Ute Pass Mini Storage, AL-18-010

Please accept the following comments from El Paso County Public Health for the project referenced above:

### UTE PASS STORAGE FACILITY

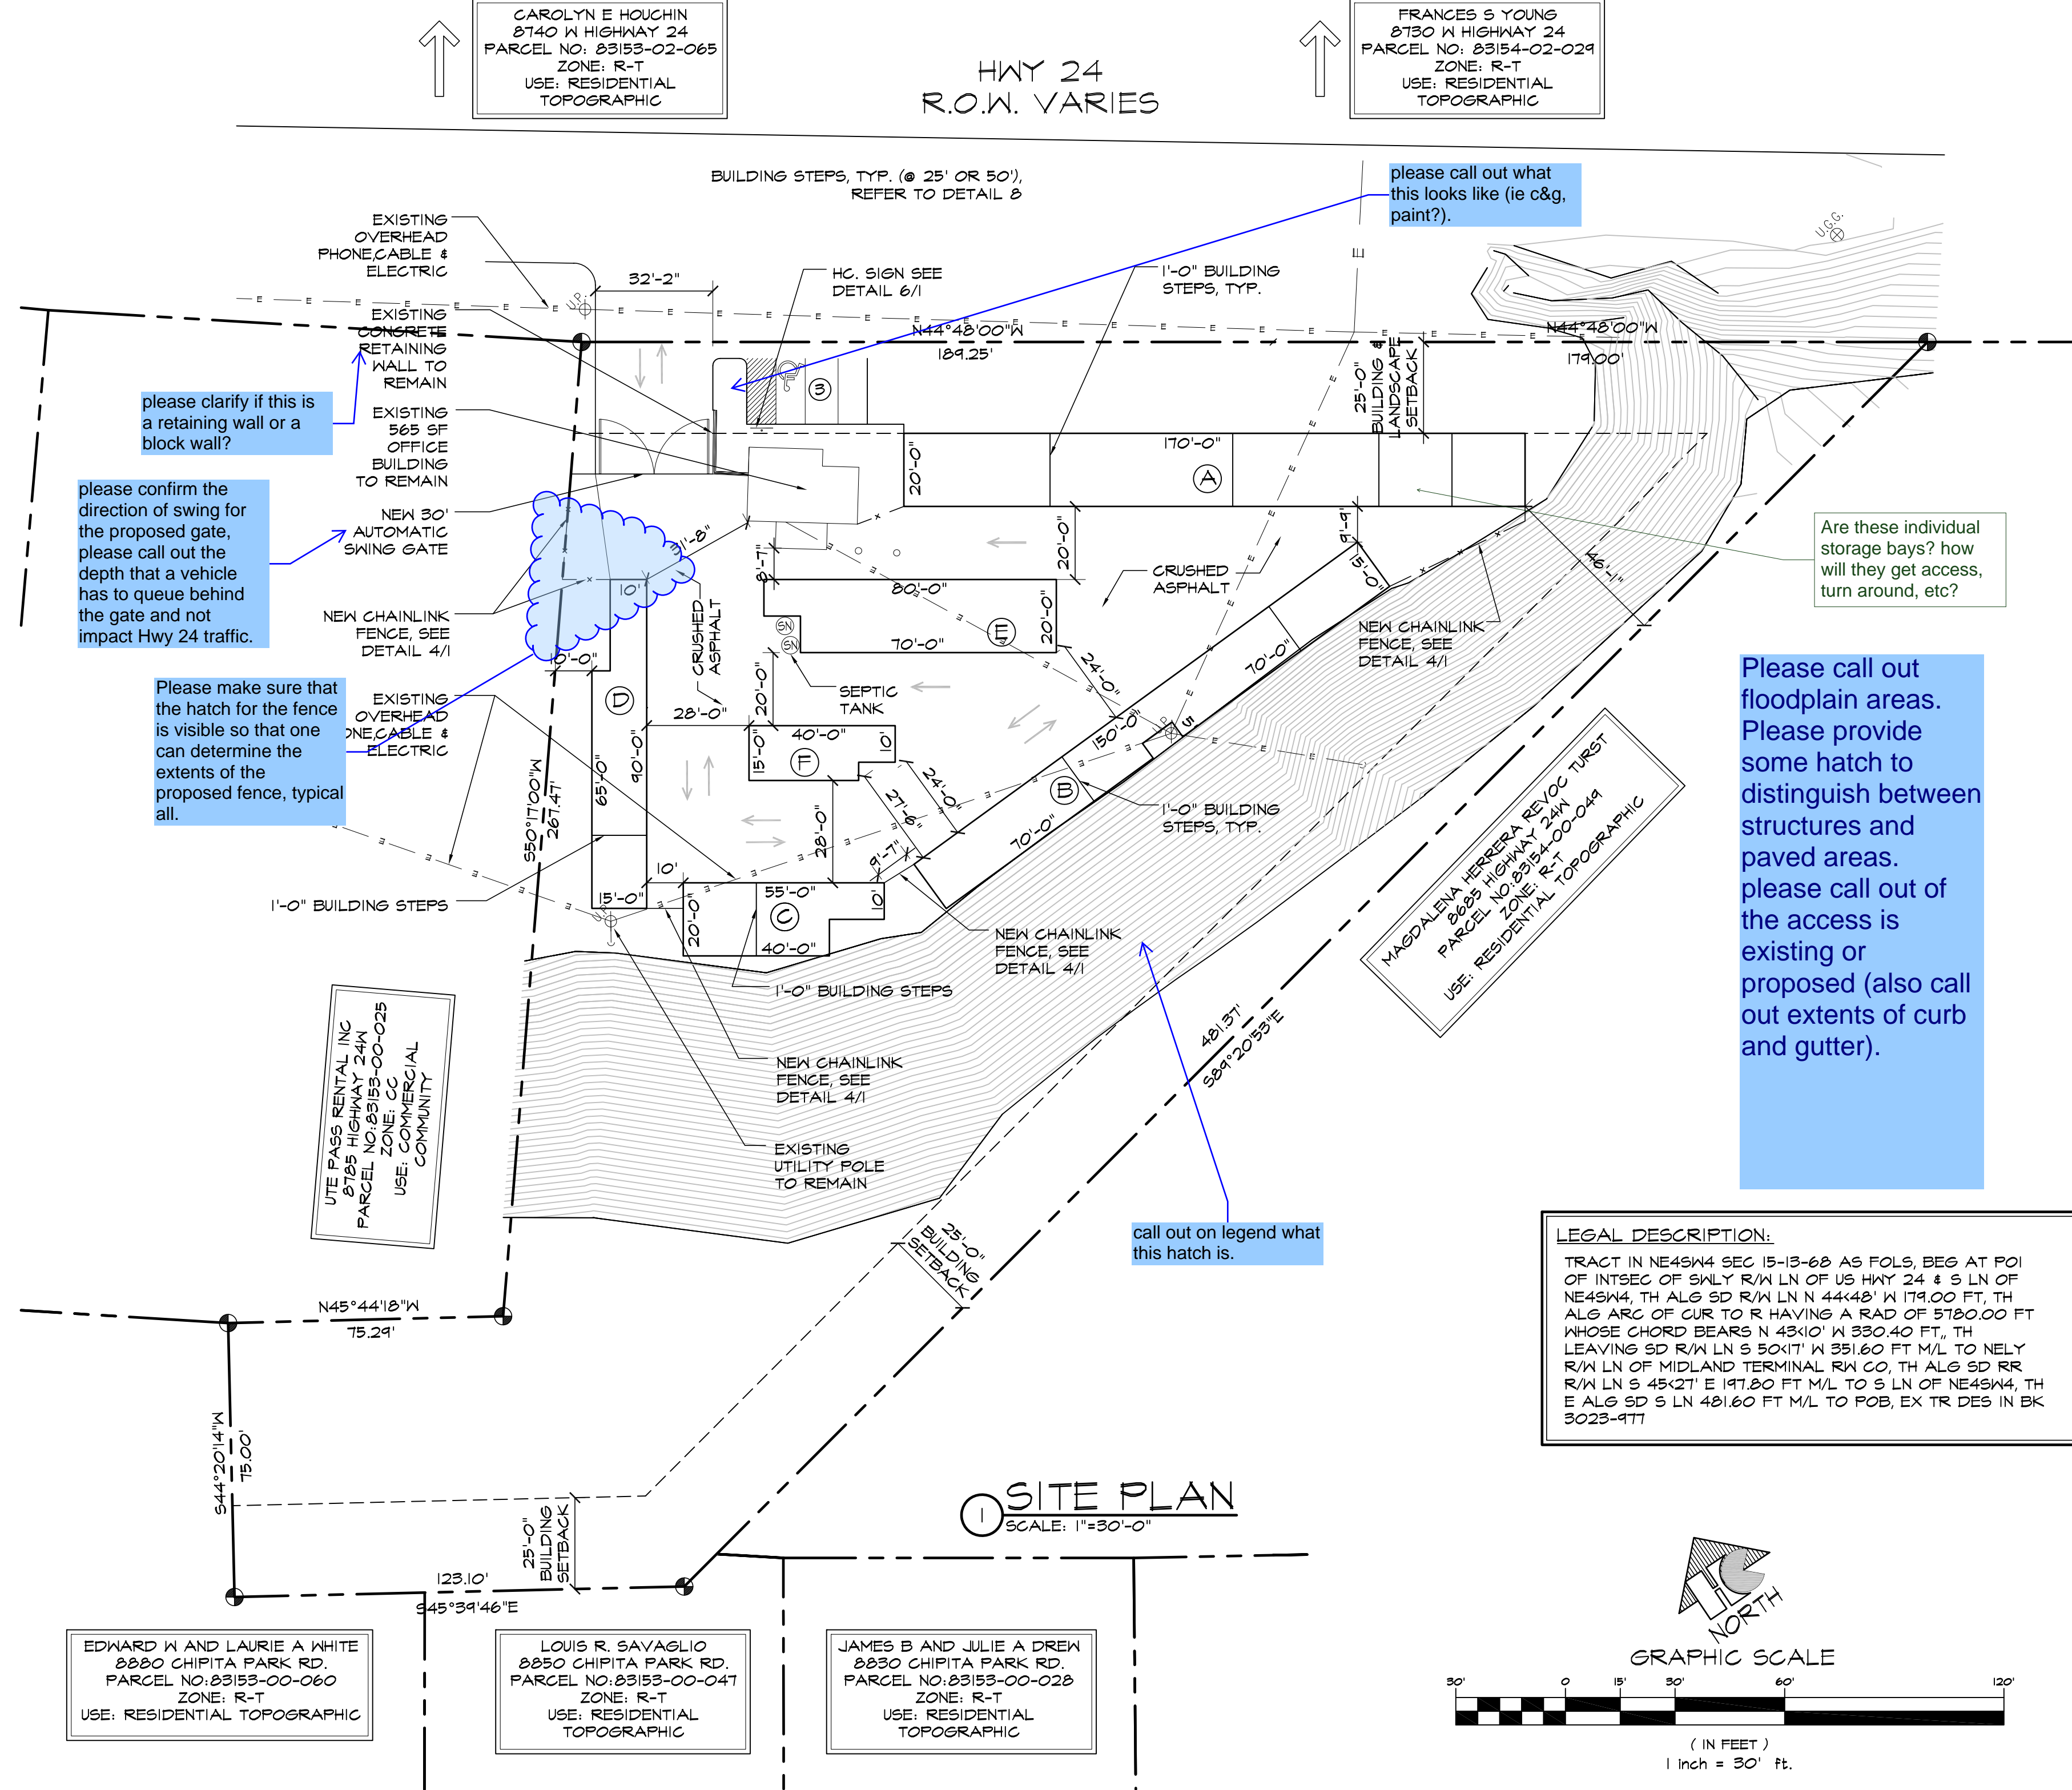
- The site development plan showed the location of a septic tank on the property, but not the soil treatment area (STA). The STA must be evaluated by a professional engineer familiar with onsite wastewater treatment systems (OWTS) to determine if the STA and septic tank are adequate for use by the office employee(s).
- El Paso County Public Health does not have any records of the OWTS installed on the property.
- The STA must be located and protected from compaction associated with construction traffic, building construction and parking.
- If earthmoving activities for the project exceed 1 acre, then go to EPCPH for a Construction Activity Permit:
<https://www.elpasocountyhealth.org/service/air-quality/construction-activity-application>
